BR/351/19/PL & BR/352/19/L

65 Upper Bognor Road (Charlotte House 71 & 71A Upper Bognor Road, 67 & 69 Upper Bognor Road Bognor Regis PO21 1HR

Listed building consent for the erection of 2 No. live-work units; change of use of existing student accommodation including internal alterations to form 2 No. dwellings, 2 No. new windows, new staircase & replacement of roof on outbuilding; reconfiguration of existing dwellings, replace existing timbers & roof joists on first floor; change of use from medical centre/offices to 2 No. flats & workshop. creation of new private gardens, separation of this part of the site from the wider University campus, creation of a shared landscaped courtyard, creation of areas for parking & storage for bins & cycles

University of Chichester
Upper Bognor Road Residential Redevelopment
Drawing
Site Plan Proposed
Scale @ A3
1:250
Drawing no.
5542-100-D3

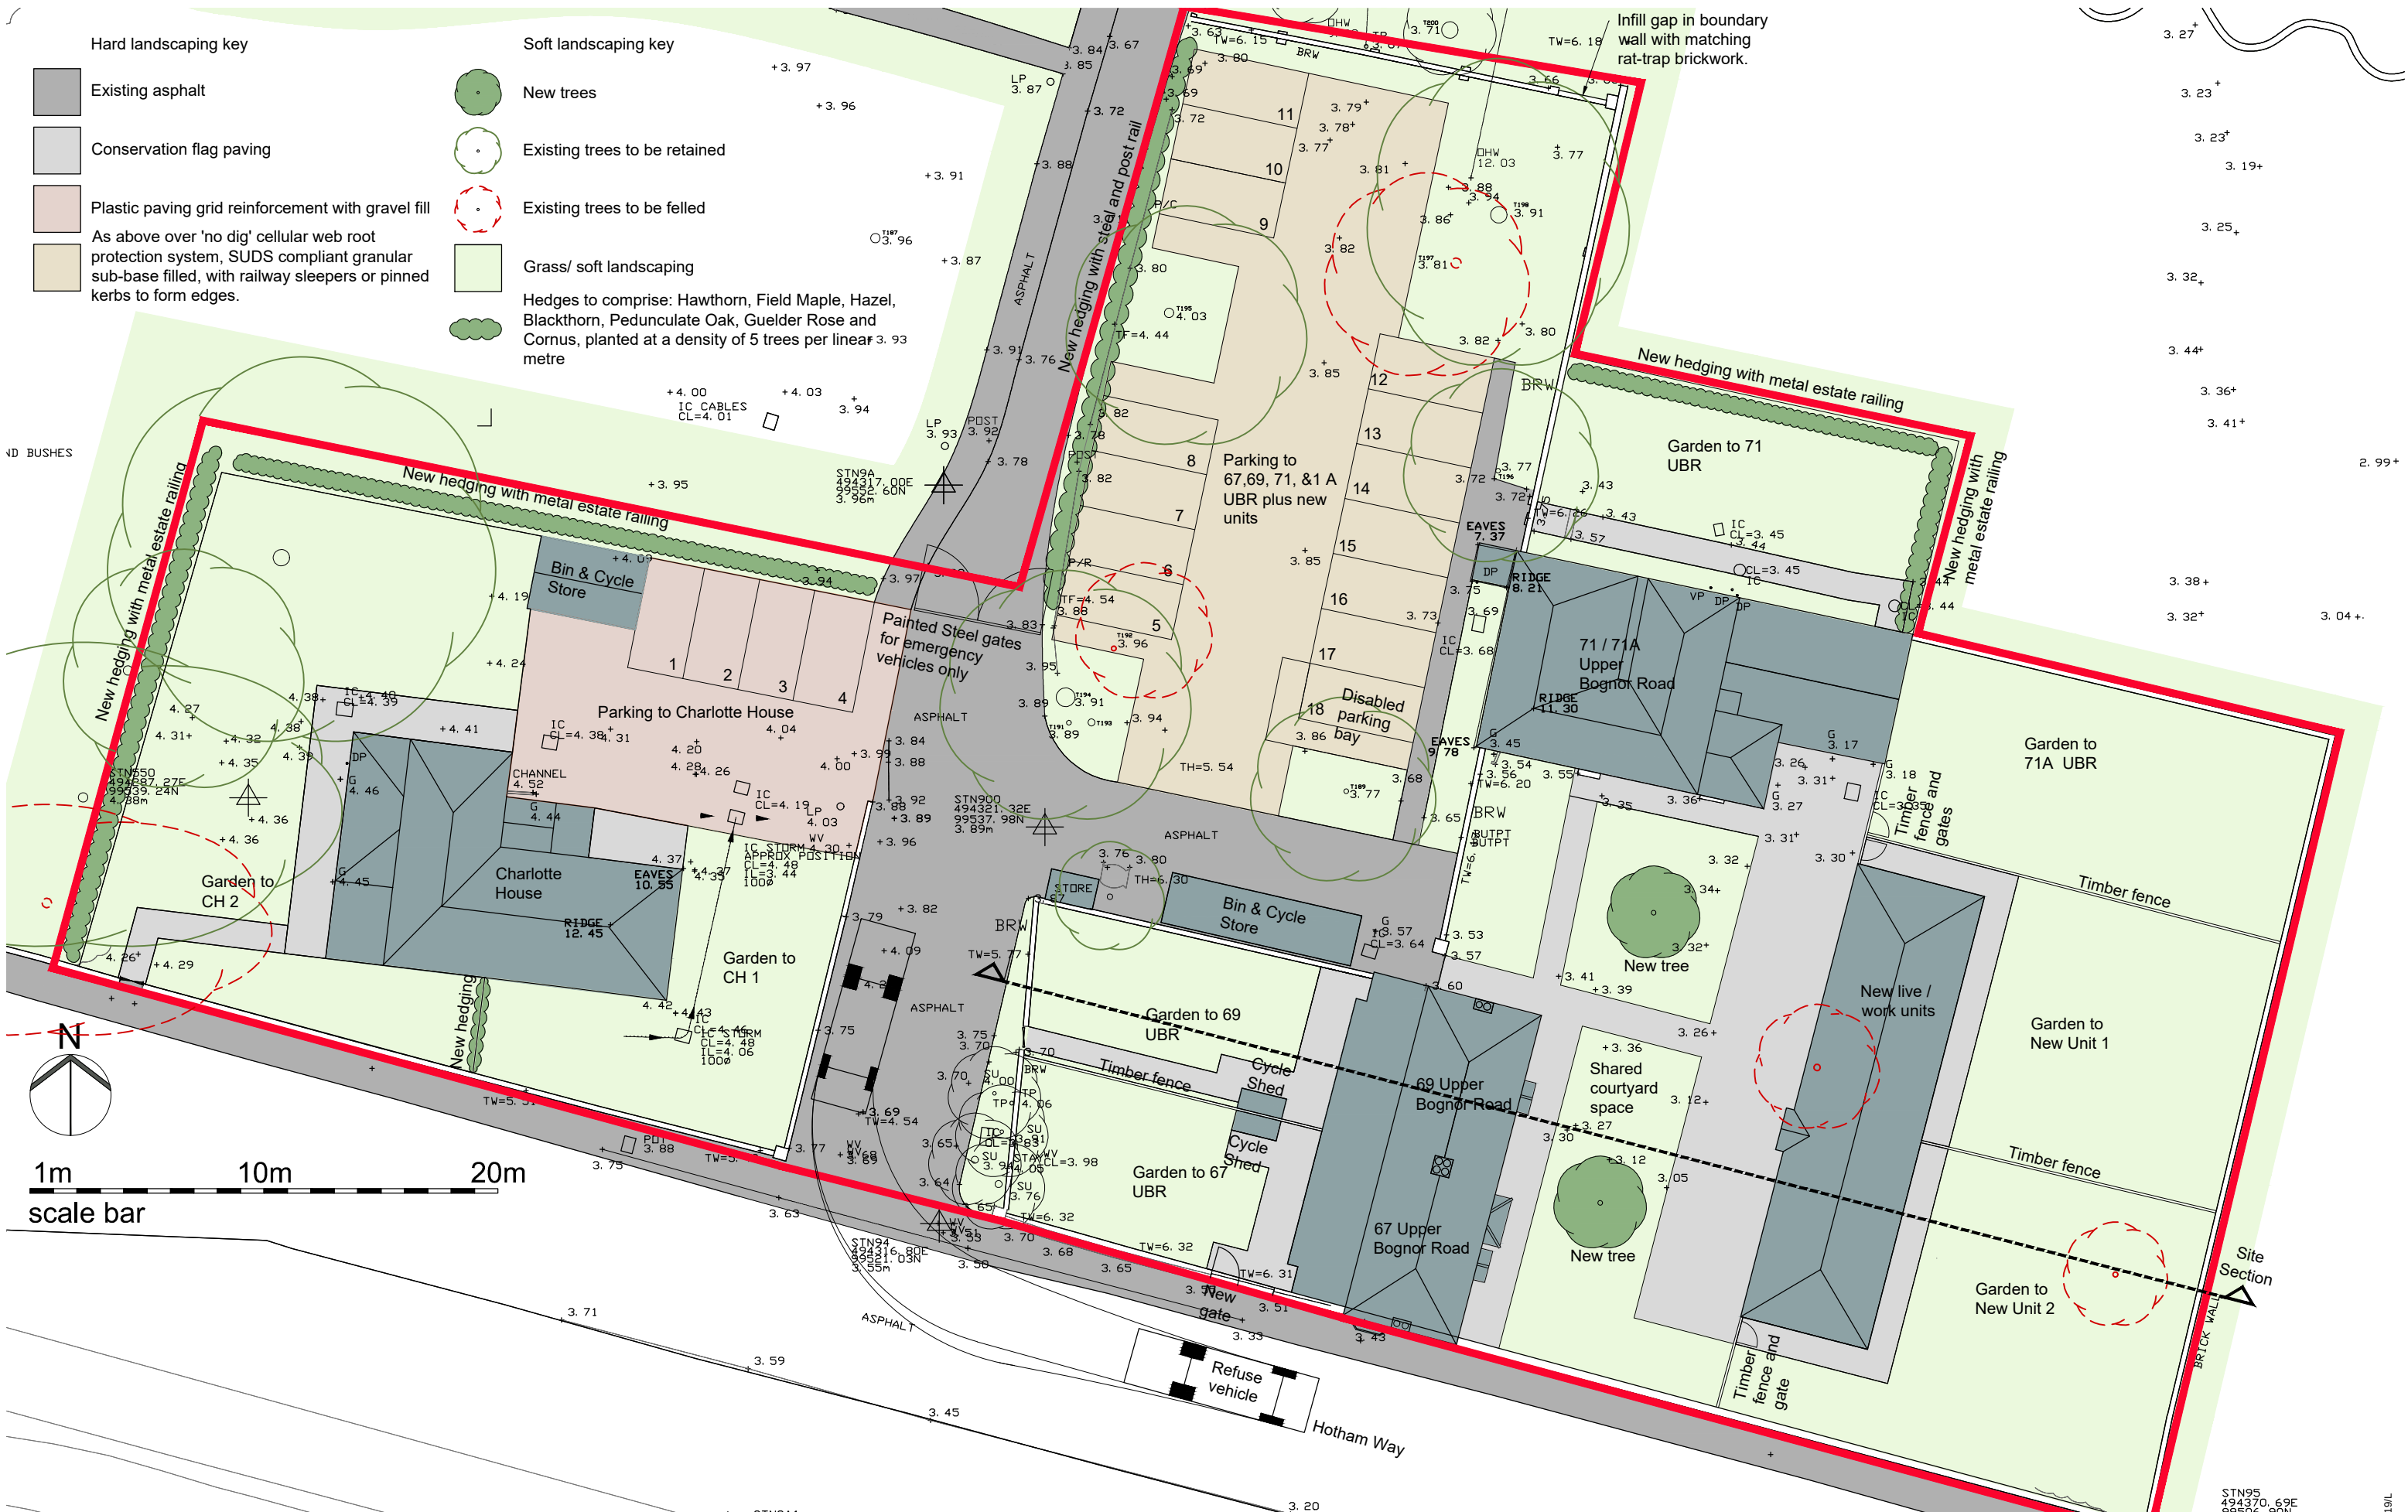
Whilst the concept of enclosing the building so that it has a private garden space is acceptable, I note from the proposed site plan that only details of the northern and western boundary treatments are provided. If not careful, the means of enclosure could cause harm to the listed building and will need to be carefully

considered; we would not wish to see a substantial amount of standard 6ft fencing used to enclose the new garden areas. This is especially the case for the eastern unit (CH1) which is currently open to the access road. Details of the means of enclosure, and their treatment are therefore required. This can be achieved through the use of a condition.

Drawing
New Live Work Units
ElevationsProposed

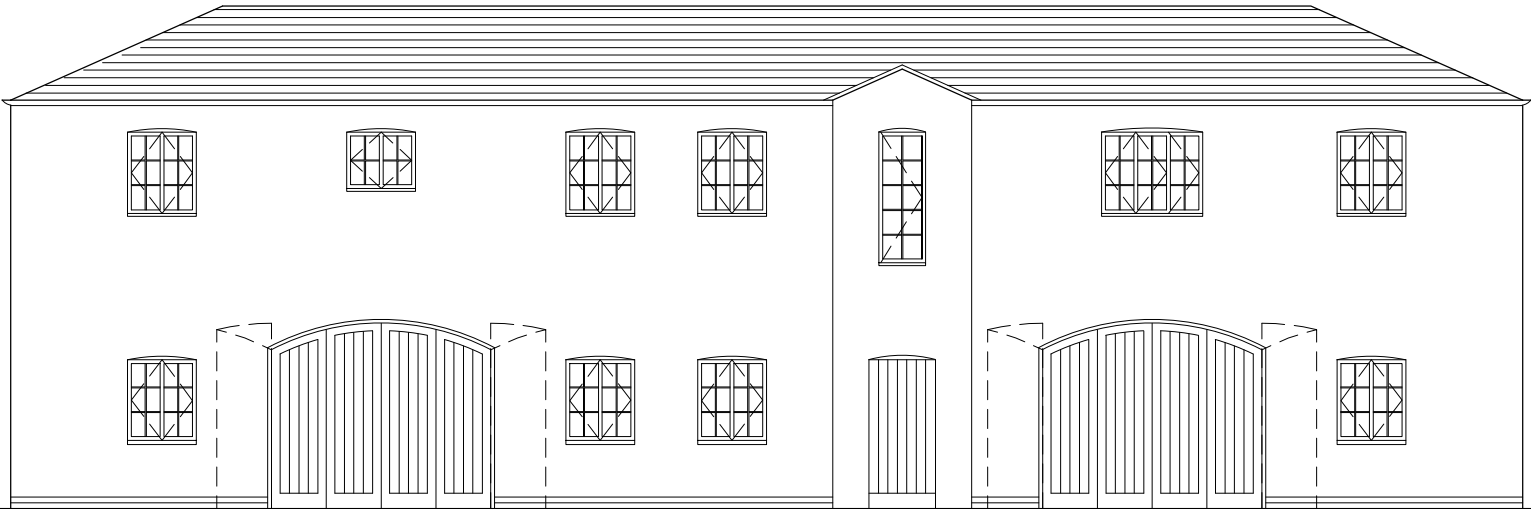
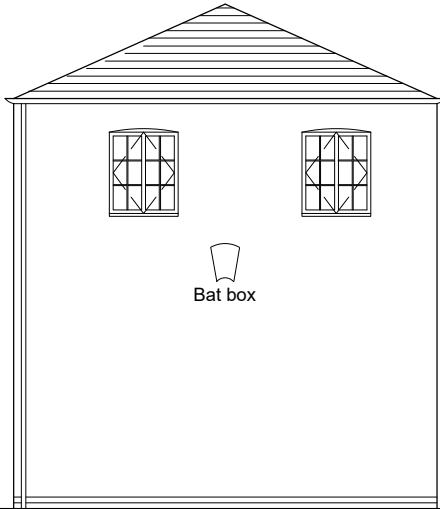
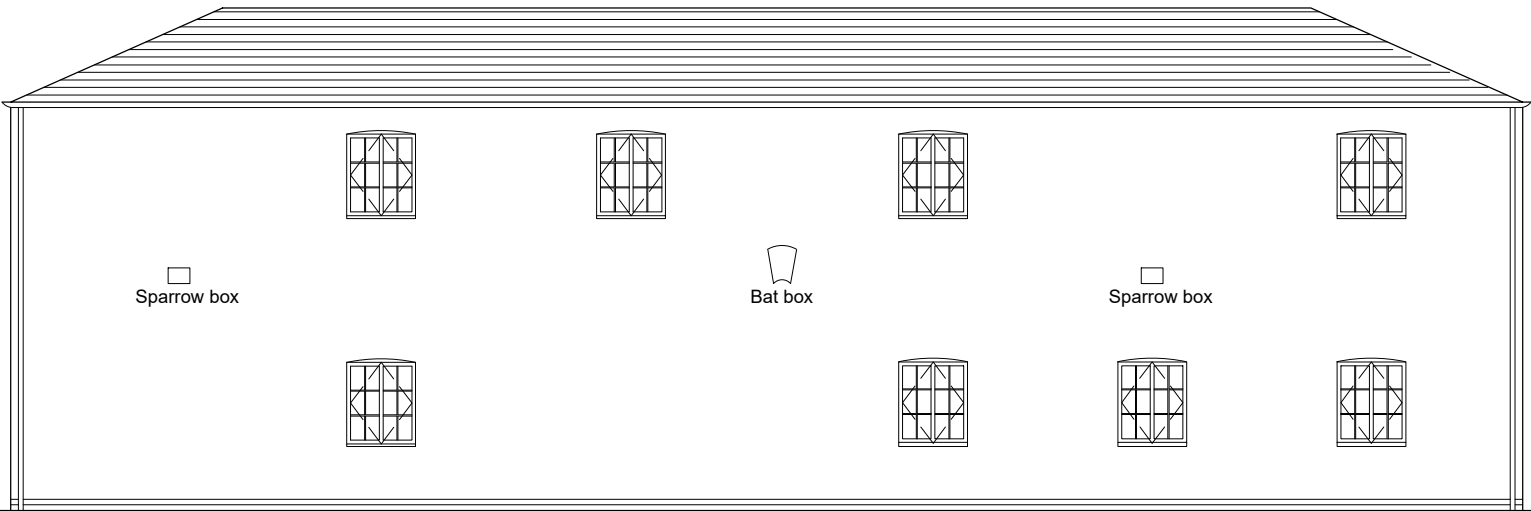
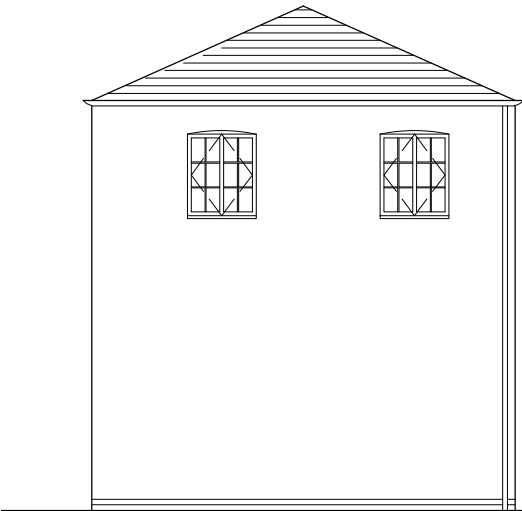
The proposed new building will accommodate both residential and workshop accommodation and will face 67 and 69 and form a courtyard with number 71. The existing group setting is of high significance, and development should be carefully considered and designed.

It is noted that the intention is for this new building to reflect the scale and appearance of the existing building. Such a concept is considered to be acceptable as long as it will truly reflect that already present, and not result in harm.

The level of detail provided at present is such that it has to be assumed that the quality will be acceptable. Further information could be provided which will confirm that this is the case, especially if the site is to be developed by a third party. Therefore, it is suggested that if you are minded to approve the application that you condition further information/drawings of the eaves, guttering etc in order to ensure that it fully reflects the existing building. It is also suggested that details of all of the materials, windows, doors, joinery and proposed external colours are provided for by way of condition. Drawings should be at a suitable scale and level of detail in order to ensure that the development is of suitable quality.
